Our Ref: BN/21/10/NMA

Application for a Non-Material Amendment following a Grant of Planning Permission BN/19/09/ to set back by 150mm the Extension on the Rear South-East Elevation.

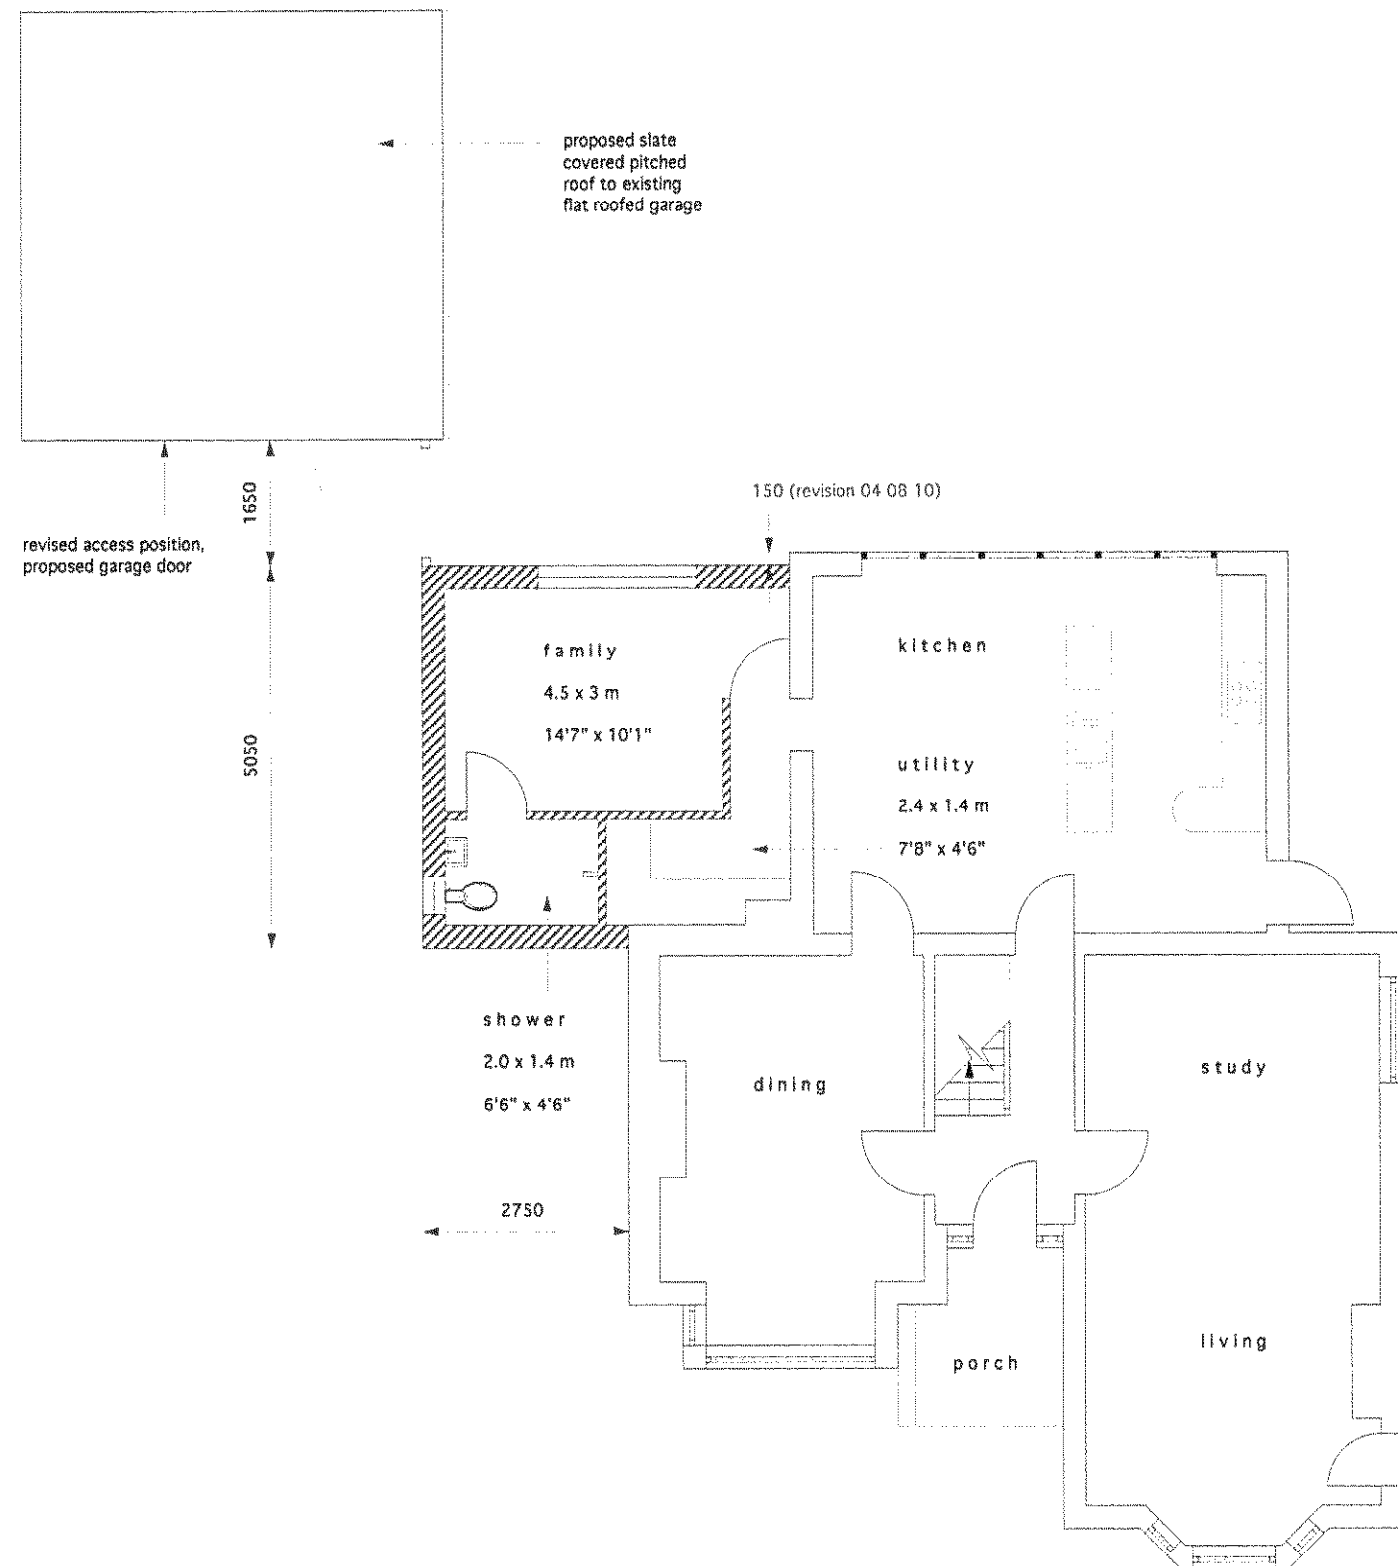
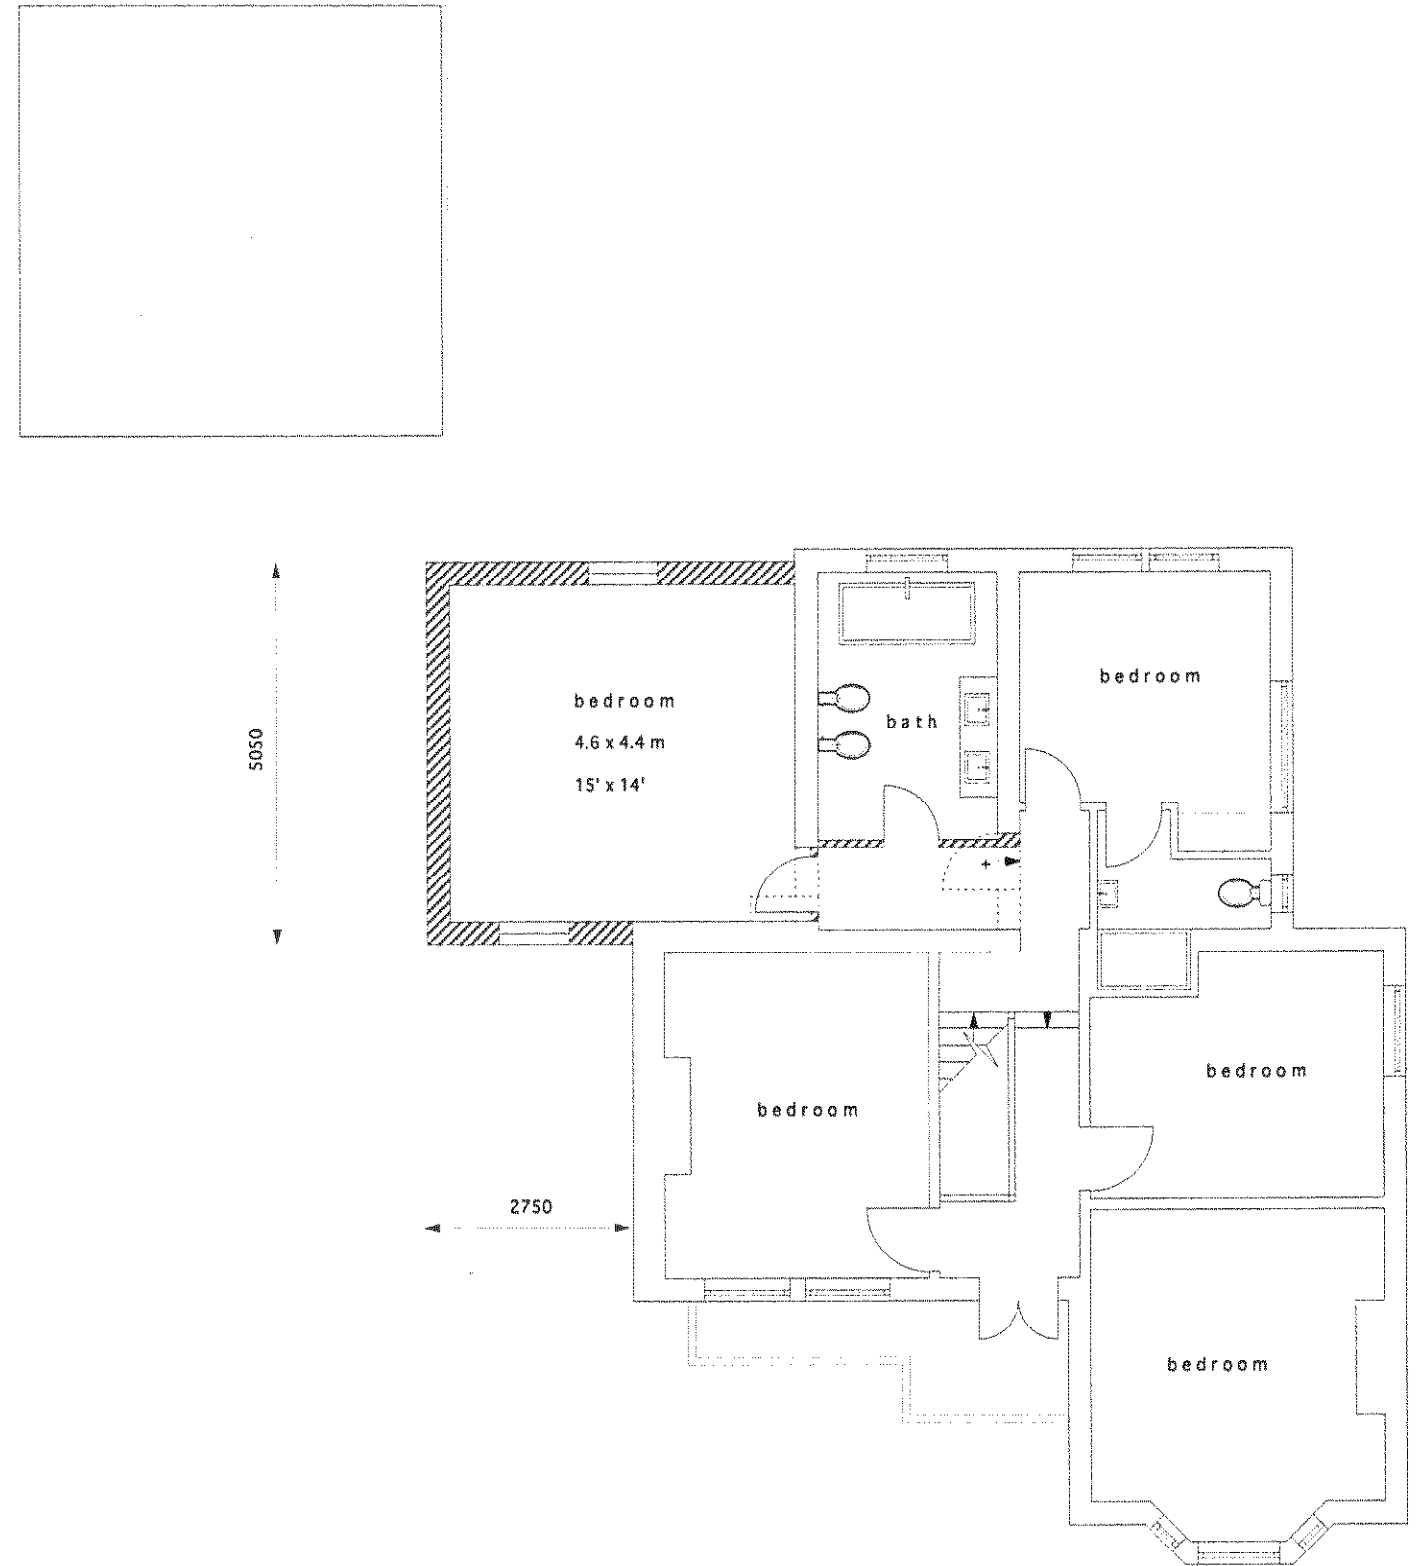
Thank you for your recent letter and enclosures regarding the above, received 13th August 2010. I can confirm that the changes identified from the Approved Plans, namely the reduction of the depth of the extension by 150mm, as show on Drawing Numbers 002, 003, 004 and 005, can be accepted as a Non-Material Amendment.
